PLANNING PORTAL REFERENCE: PP-12829691
APPLICATION FOR NON-MATERIAL AMENDMENT PURSUANT TO PLANNING APPLICATION
REFERENCE: 6/2022/2249/VAR. ON BEHALF OF HERTFORDSHIRE CONSTABULARY AND
WILLMOTT DIXON.
HERTFORDSHIRE CONSTABULARY, STANBOROUGH ROAD, WELWYN GARDEN CITY,
HERTFORSHIRE, AL8 6XF.

“Non-Material Amendment Application for amendments to the façade and elevations of the Headquarters building pursuant to application reference: 6/2022/2249/VAR.”

**Proposed Headquarters Building
Proposed Elevations Sheet 1 of 5**

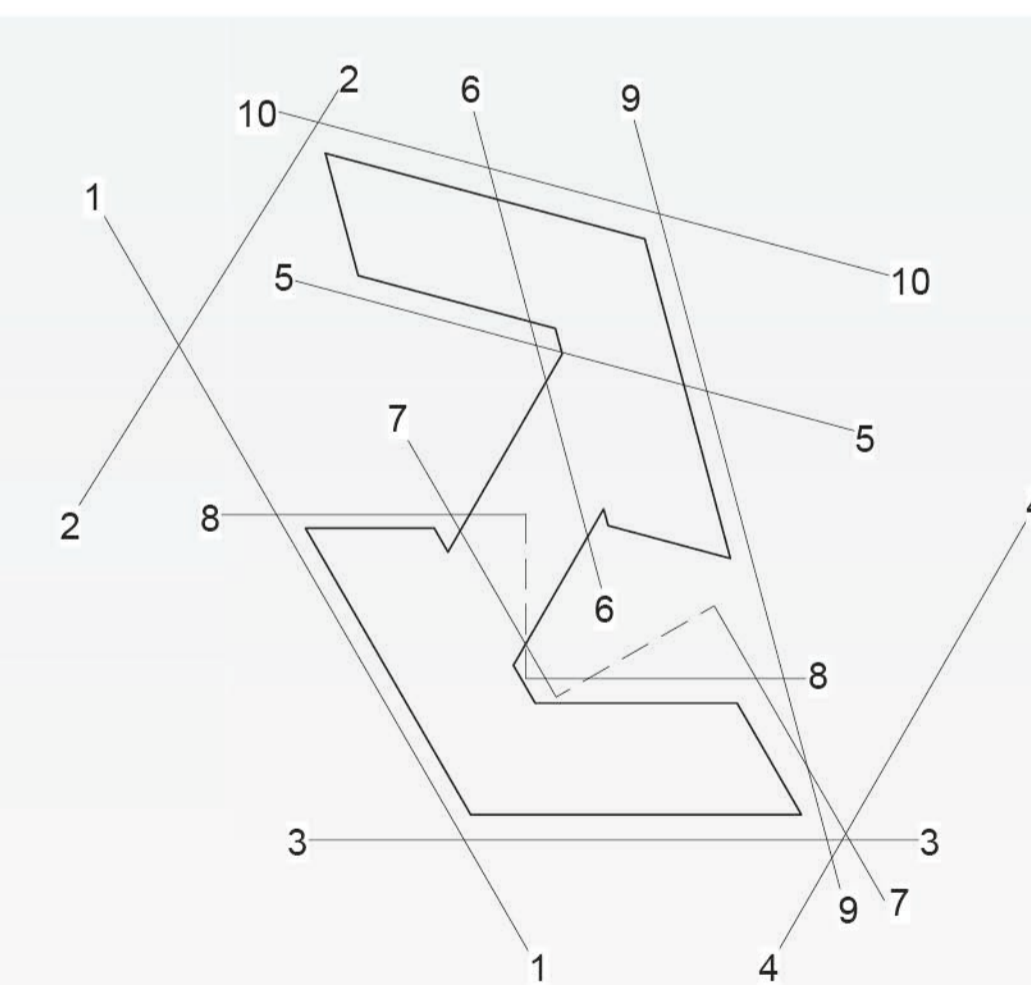
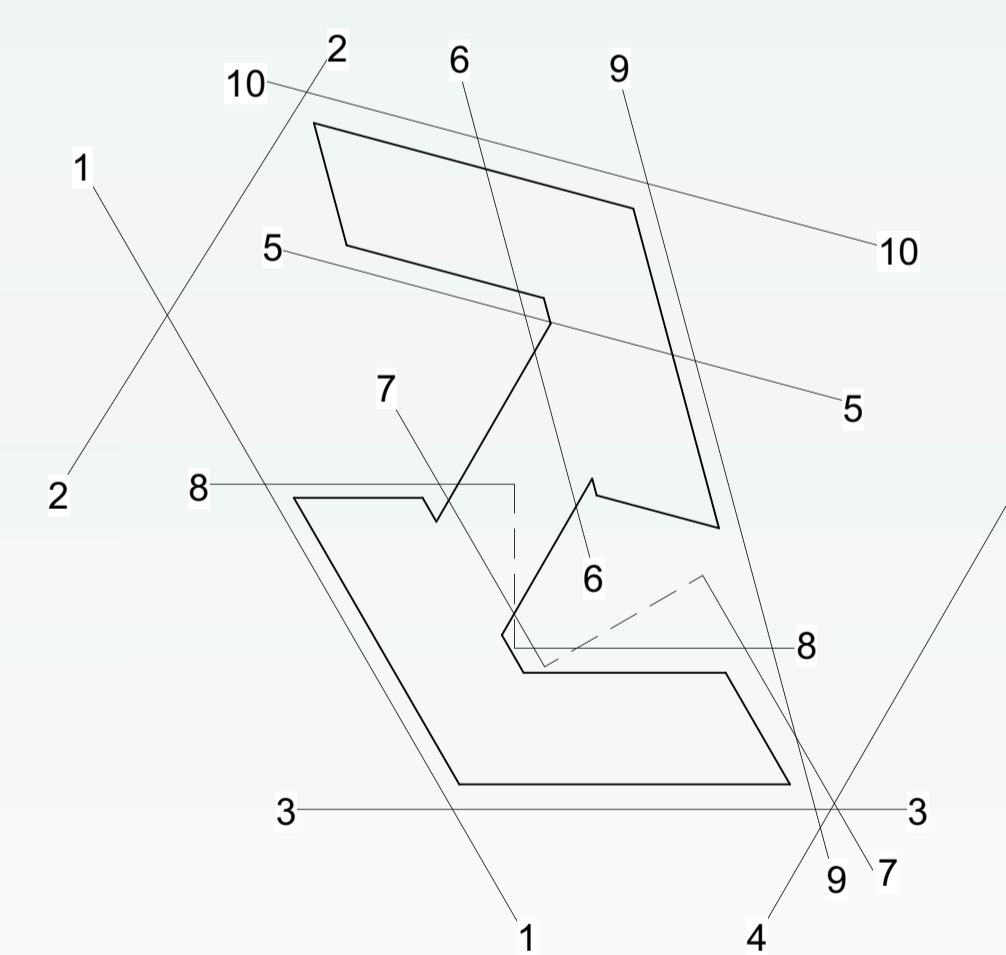
- Amendments to the proposed atrium – including a reduction in the floorspace, minor alterations to the layout, removal of external columns, repositioning of meeting rooms
- Amendments to the roof area which includes a reduction in the roof area of the atrium and the omission of rooflights. Also, 1 plant screen has been removed due to the reduction in the number of Air Handling Units required.
- Amendments to the kitchen area – increase in the size of the kitchen, reduction in the servery size and repositioning of the catering office.
- Amendments to the configurations of some of the rooms and the uses of these rooms, leading to repositioning of windows.
- Reduction in the building height by circa 500mm.
- Reduction in the height of the Glulam roof by circa 250mm.
- Amendments to the ground floor plant room with the re-positioning of doors and louvres.
